Appeal Decision

Appeal Ref: APP/R5510/W/23/3318295

35 Bedford Avenue, Hayes UB4 0DP

- The appeal is made under section 78 of the Town and Country Planning Act 1990 against a failure to give notice within the prescribed period of a decision on an application for planning permission.
- The appeal is made by Mr Setandar Junaja against the London Borough of Hillingdon.
- The application Ref 64163/APP/2022/2894, is dated 15 September 2022.
- The development proposed is a ground floor side extension, first floor rear extension and a change of use from a house to two flats.

BLOCK PLAN SCALE 1 : 200 at A4
35 BEDFORD AVENUE UB4 0DP
SHOWING PROPOSED ALLOCATION
OF OPEN SPACE BETWEEN THE FLATS
DRAWING: CH/SUNNY/32 9th SEPTEMBER 2022.

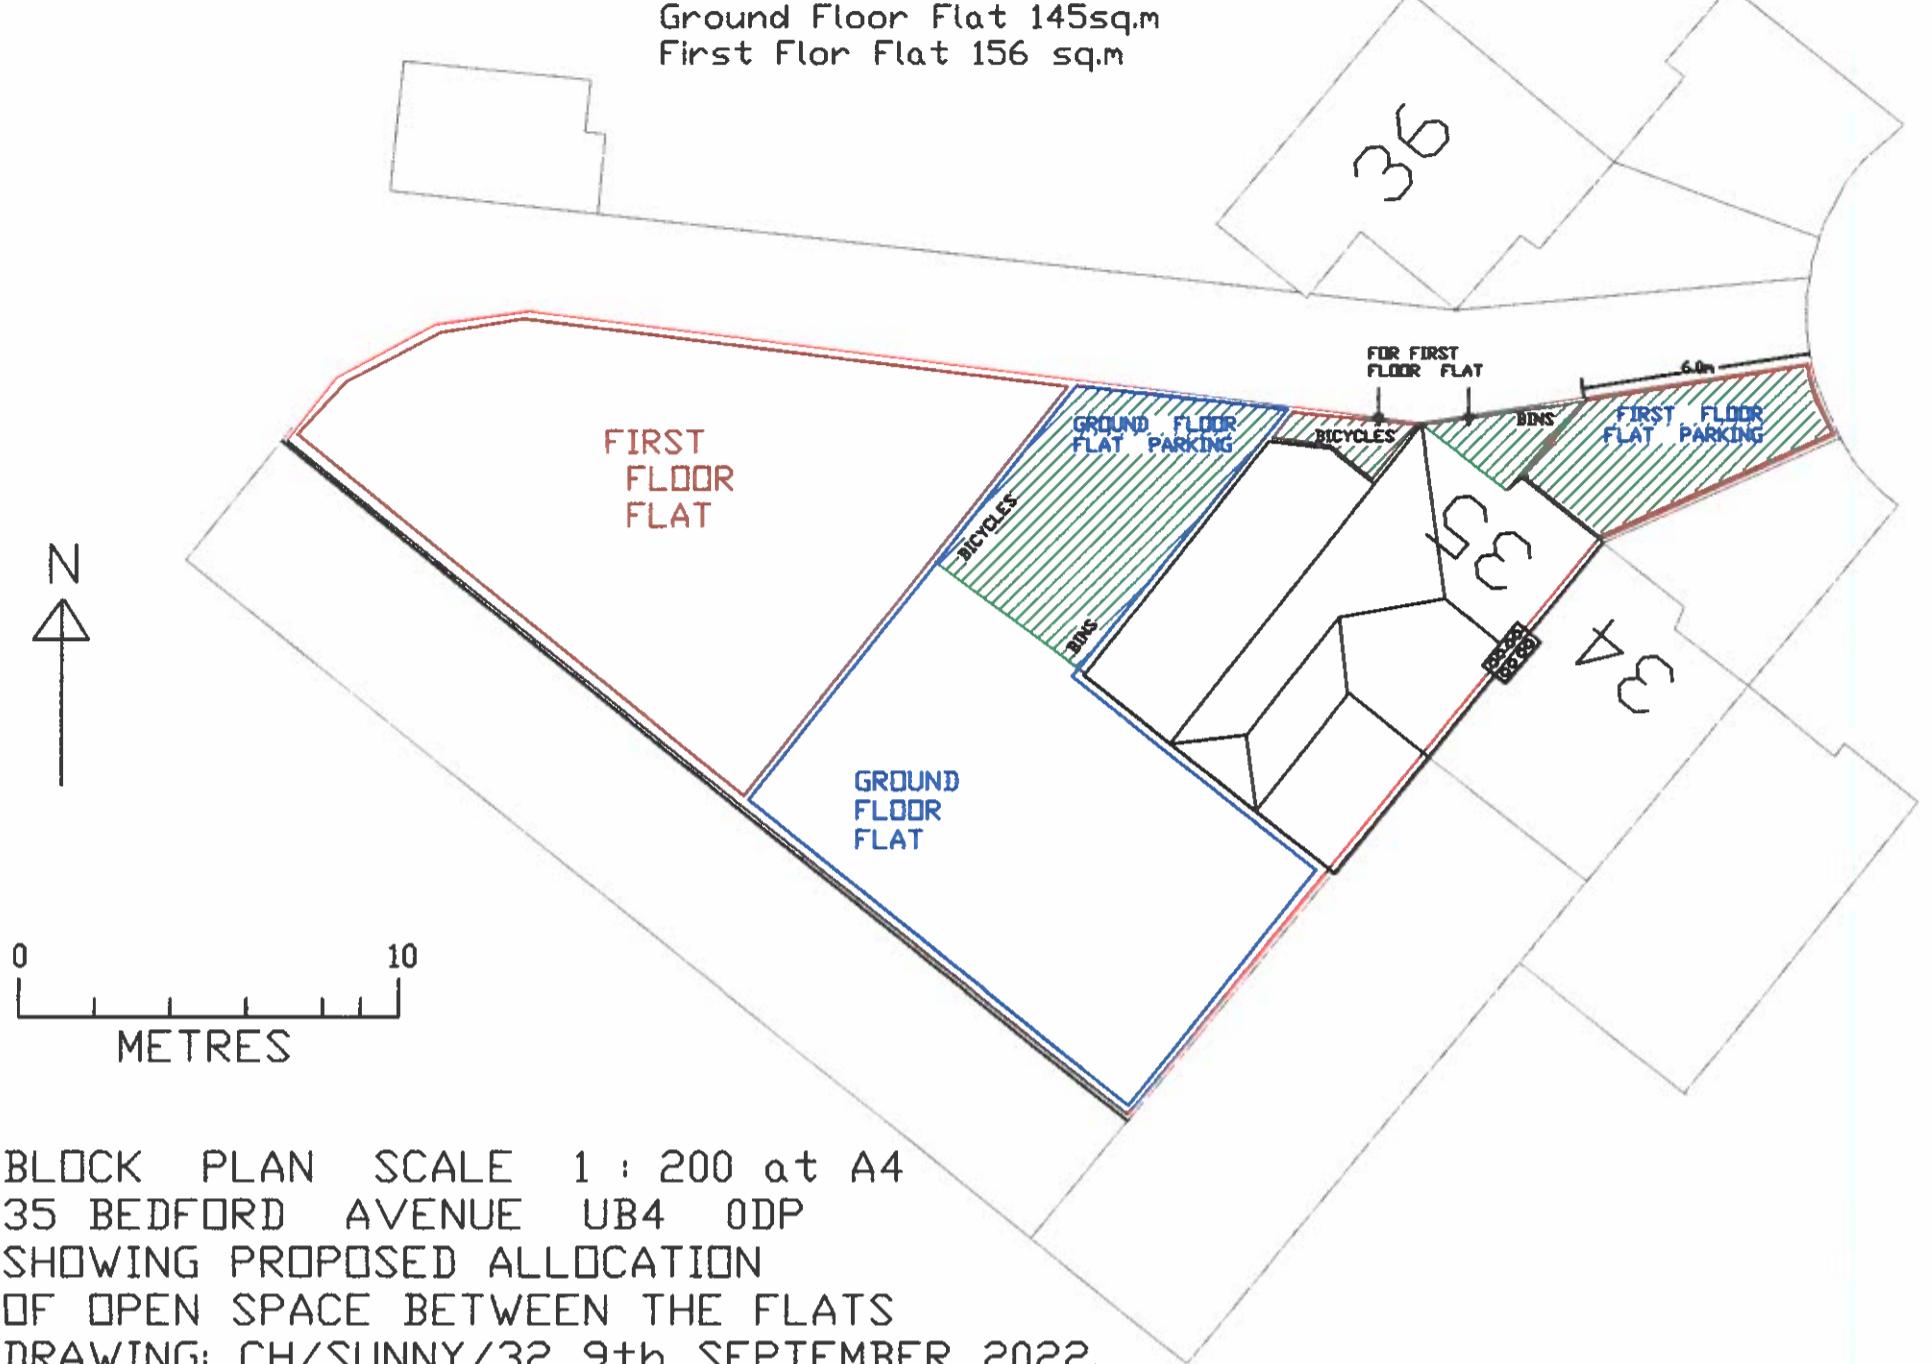
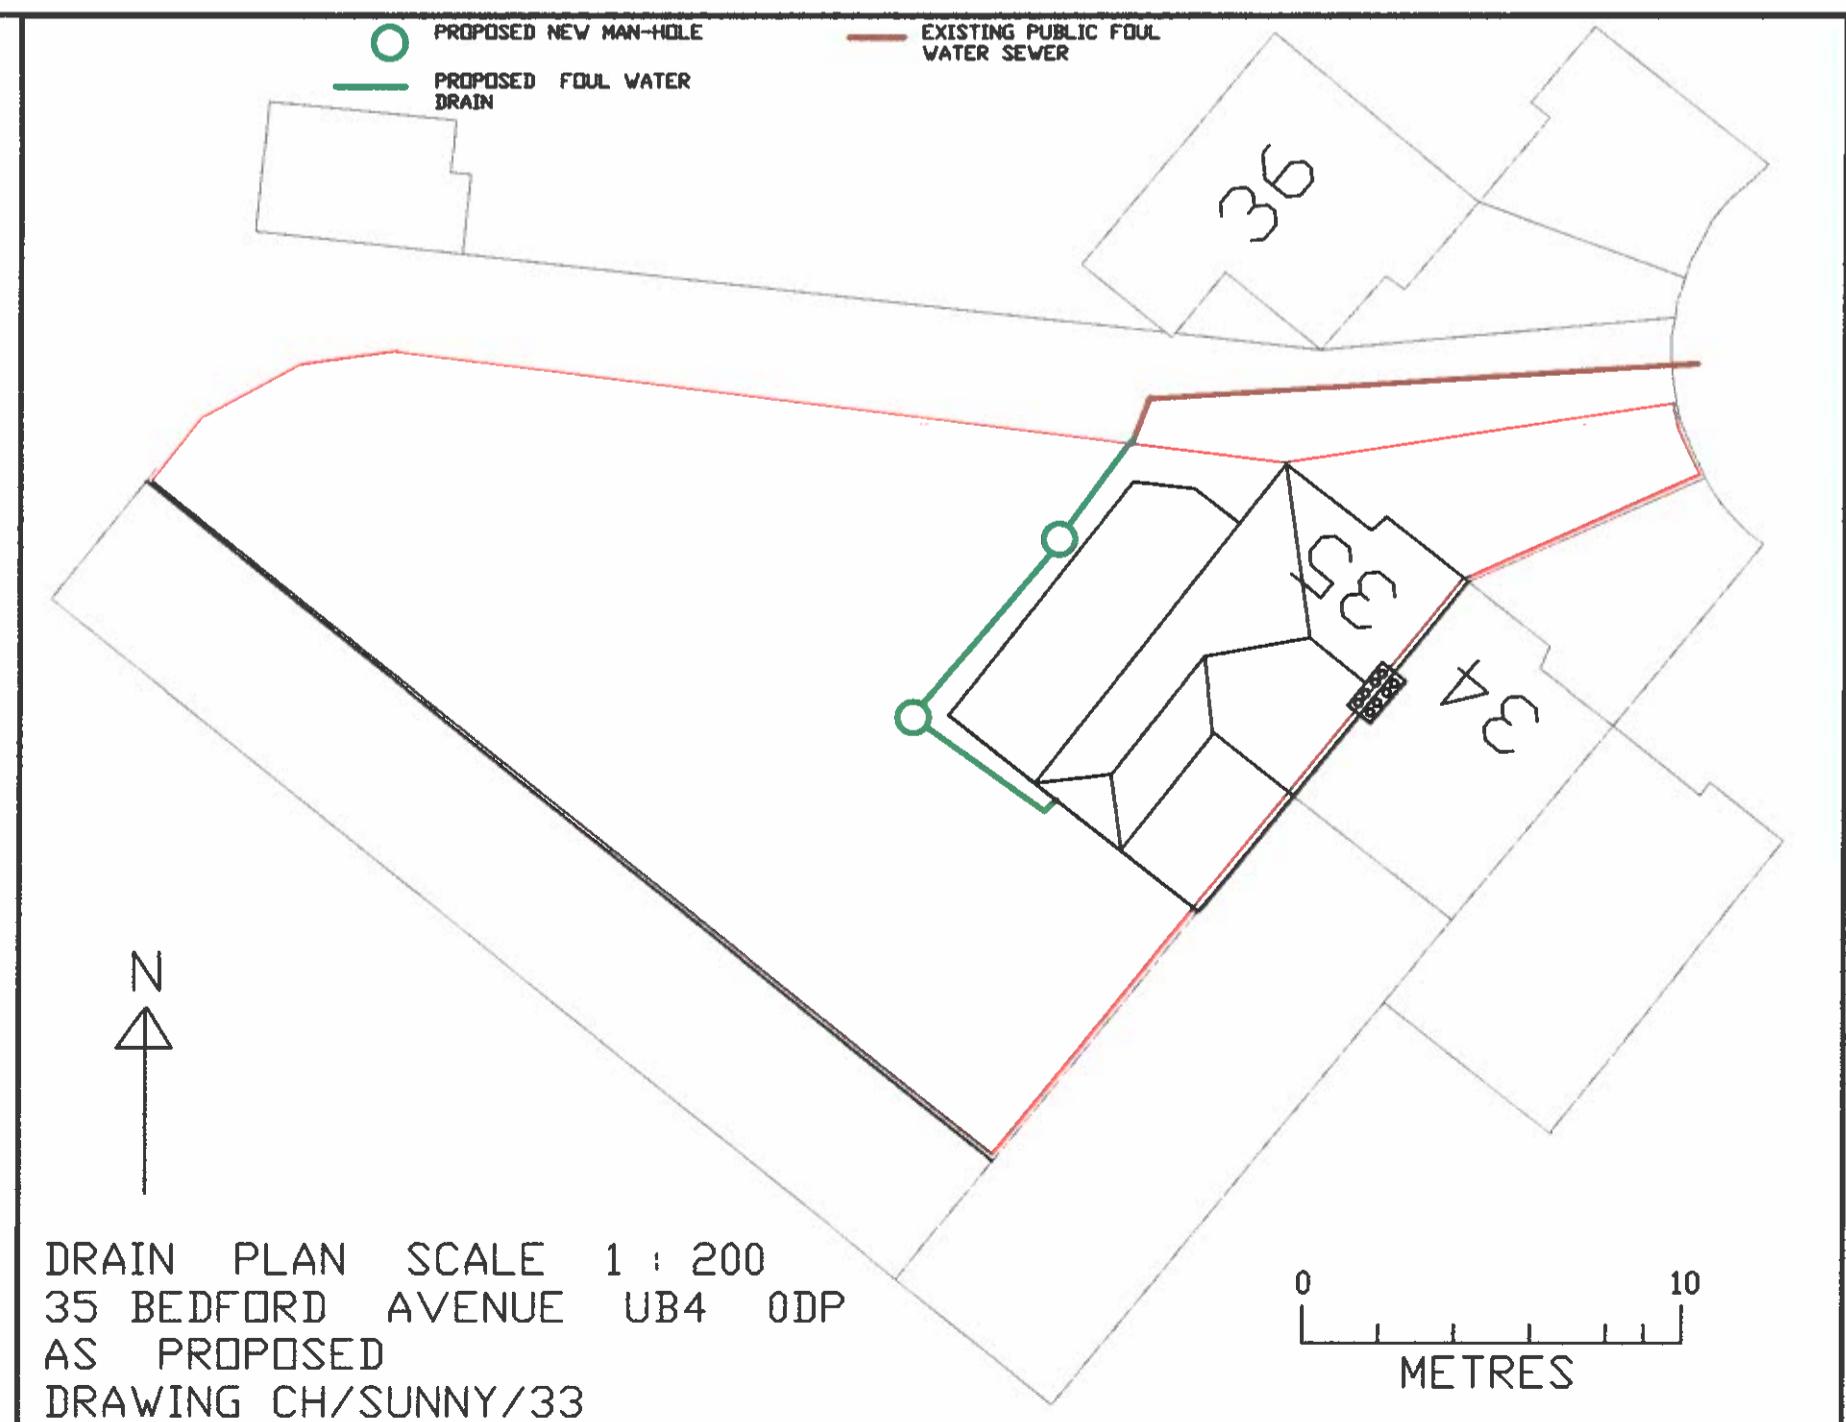
7. The proposed parking for the first floor flat is shown in the plans as using the existing on-site parking space on the front forecourt of the property. Parking for the ground floor flat is shown as space immediately to the north west of the proposed ground floor side extension.

8. Amenity space for each flat is shown as a rectangular area to the rear of the property for the ground floor flat and a triangular parcel of land to the north west of this area is shown as the amenity area for the first floor flat. How access by foot into that amenity area would be gained is not shown on the plans.

12. It is clear that in order to use the vehicular parking space for the ground floor flat, and in order to access the ground floor flat on foot, and to gain access to the amenity land dedicated to the first floor flat there would have to be use of the private accessway. No documentation to support those statements is submitted with the appeal. Nevertheless, as the land necessary to support pedestrian and/or vehicular movements in order to use the appeal site as flats has not been included in the red-lined area then owners with a legal interest in that land have not been notified of the application or appeal. Notice would have had to have been served on other landowners if the scheme used land outside the red-lined application site. In this case it does. It is not possible to rule out the possibility that a landowner has been prejudiced in not being notified about use of the accessway.

13. As such the proposal fails to demonstrate how the ground floor flat pedestrian access and parking space could be used when relying only on the land within the application/appeal site. Furthermore, the private right of way is fairly narrow and there is no evidence of turning movements to show how a vehicle could manoeuvre in and out of the ground floor flat parking space easily. Reversing into it from Bedford Avenue would appear to be awkward and

potentially hazardous to pedestrians and being able to leave the parking space in a forward gear if the space was entered in a forward gear is also unproven on the documentation before me.

22. The submitted plans identify dedicated amenity space for the ground floor flat to the rear of the building. This could be easily accessed from the main door to the ground floor flat. It would be overlooked by future occupants of the first floor flat but that would not be sufficient reason in my view to refuse planning permission in this case in this close-knit residential area. Amenity space for the first floor flat is shown on the submitted plans as a freestanding parcel of land in the north western area of the appeal site. It would appear that pedestrian access over this could only be via the accessway which is outside the red line of the application site. Consequently, for reasons referred to in relation to issue 1 above, there is insufficient information to demonstrate how that garden land could be accessed using only the red-lined application site area.

35 BEDFORD AVENUE HAYES UB4 0DP  
PLANNING PERMISSION APPLICATION  
SINGLE STOREY SIDE AND REAR TWO  
STOREY EXTENSIONS & CHANGE OF USE  
FROM SINGLE RESIDENCE TO TWO FLATS  
FLOOR PLANS & EAST ELEVATION  
DRAWING: CH/SUNNY/34/A SCALE 1 : 100 at A3  
DATE 9th SEPTEMBER 2022.

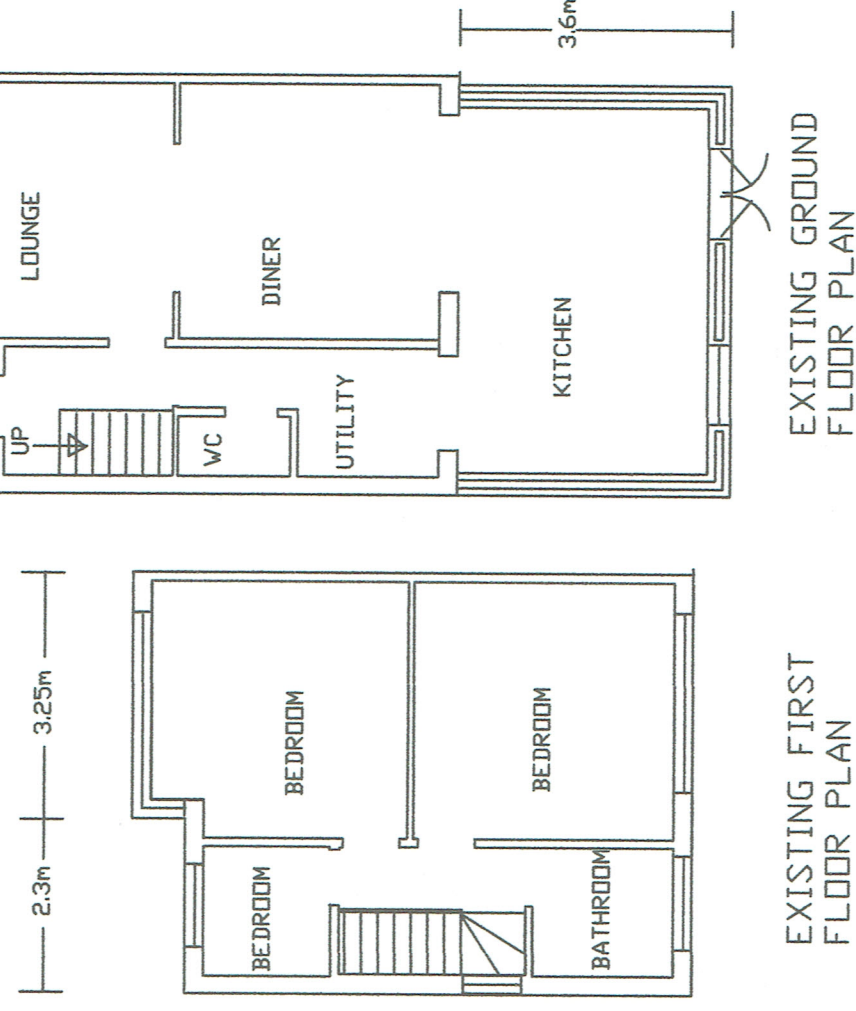
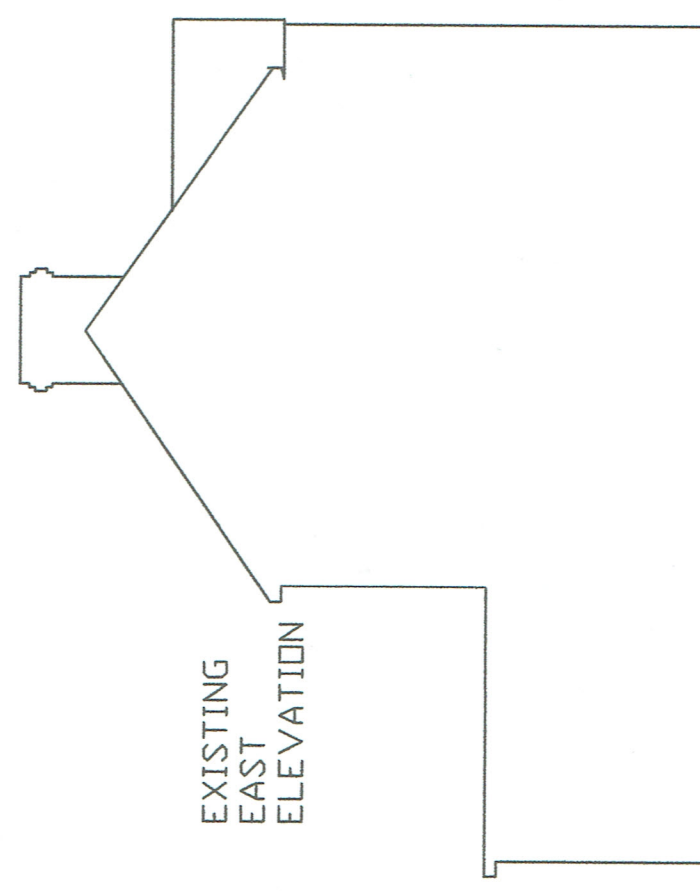
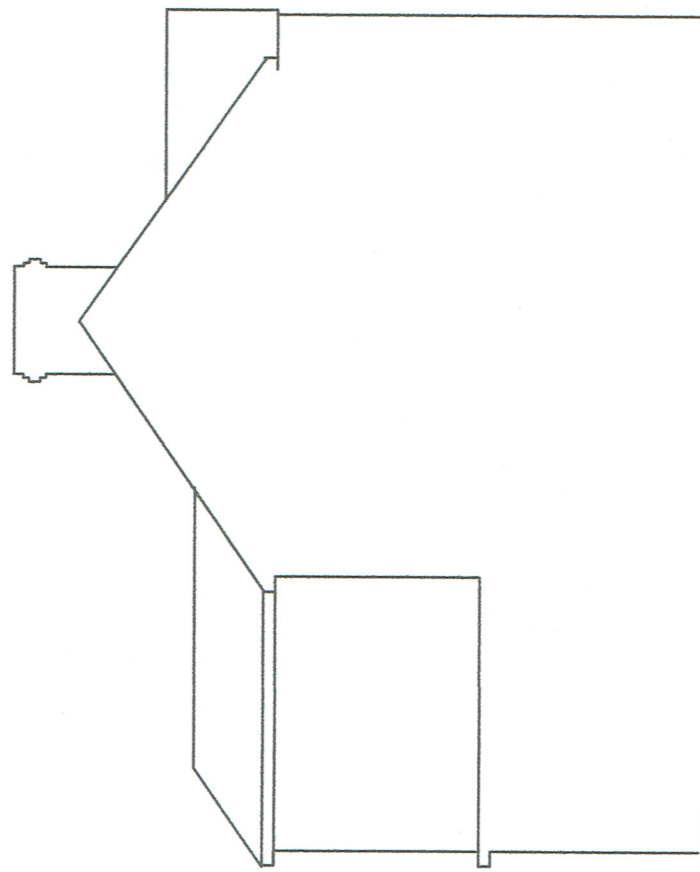
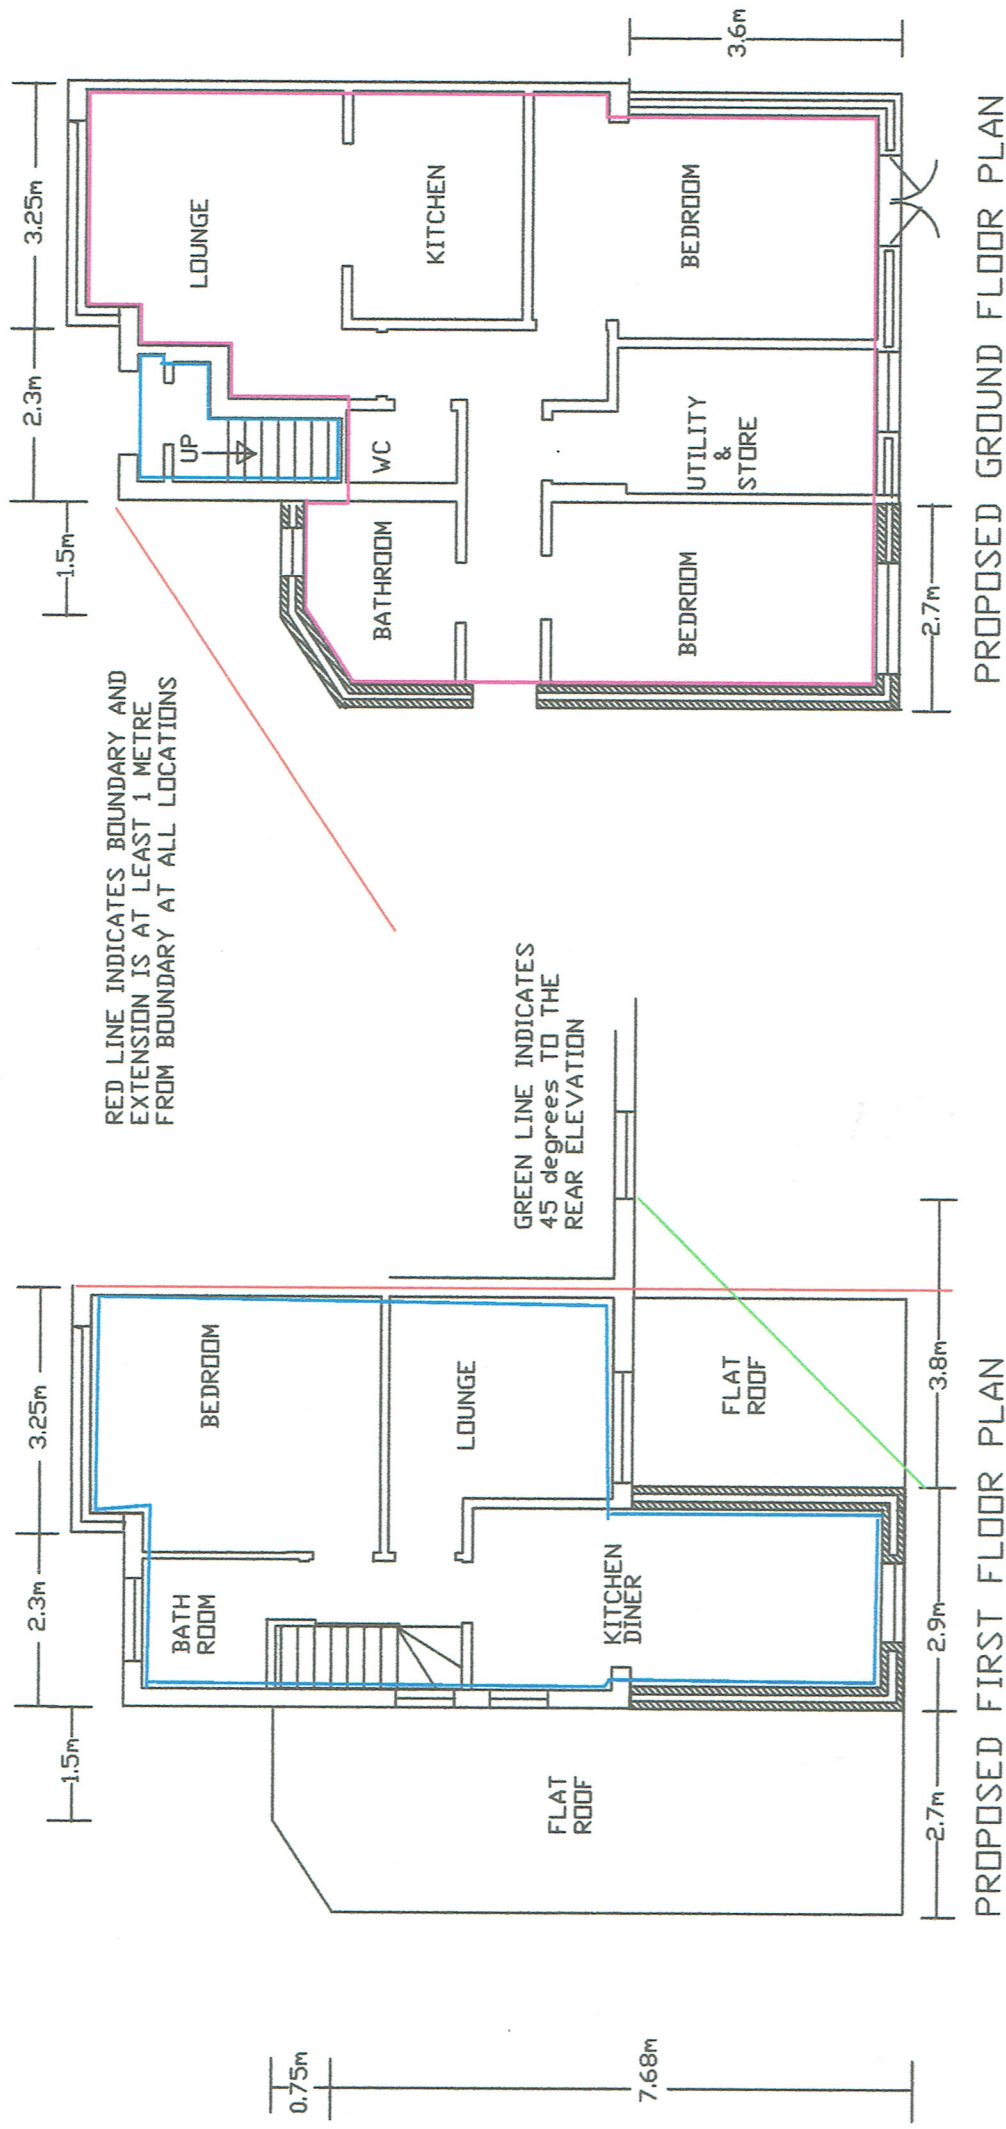
6. Conversion of the house into two self-contained flats is also sought as part of the scheme. There would be a ground floor two bedroomed flat with an entrance off the proposed new ground floor side extension. This would entail a future occupant of the ground floor flat walking along the accessway in order to access the ground floor flat. The upper floor would comprise a one bedroomed flat and would incorporate the proposed new first floor extension. Its entrance would be from the existing front door at the front of the property.

17. Policy DMHB 16 of LP2 states that all housing development should have an adequate provision of internal space in order to provide an appropriate living environment. To achieve this all residential development or conversions should meet or exceed the most up-to-date internal space standards as set out in Table 5.1. The standards in Table 5.1 are the same as those in Table 3.1 of policy D6 of the London Plan 2021. Those include the advice that a one storey dwelling with 1 bedroom 2 person occupancy as is the case for this appeal proposal should provide a gross internal area of at least 50sqm. The first floor flat would provide less than 50sqm GIA and so would fail to meet that standard by more than a small margin.

18. The London Plan also advises that a floor to ceiling height of at least 2.5m is required and the submitted drawings fail to demonstrate that that would be achieved.
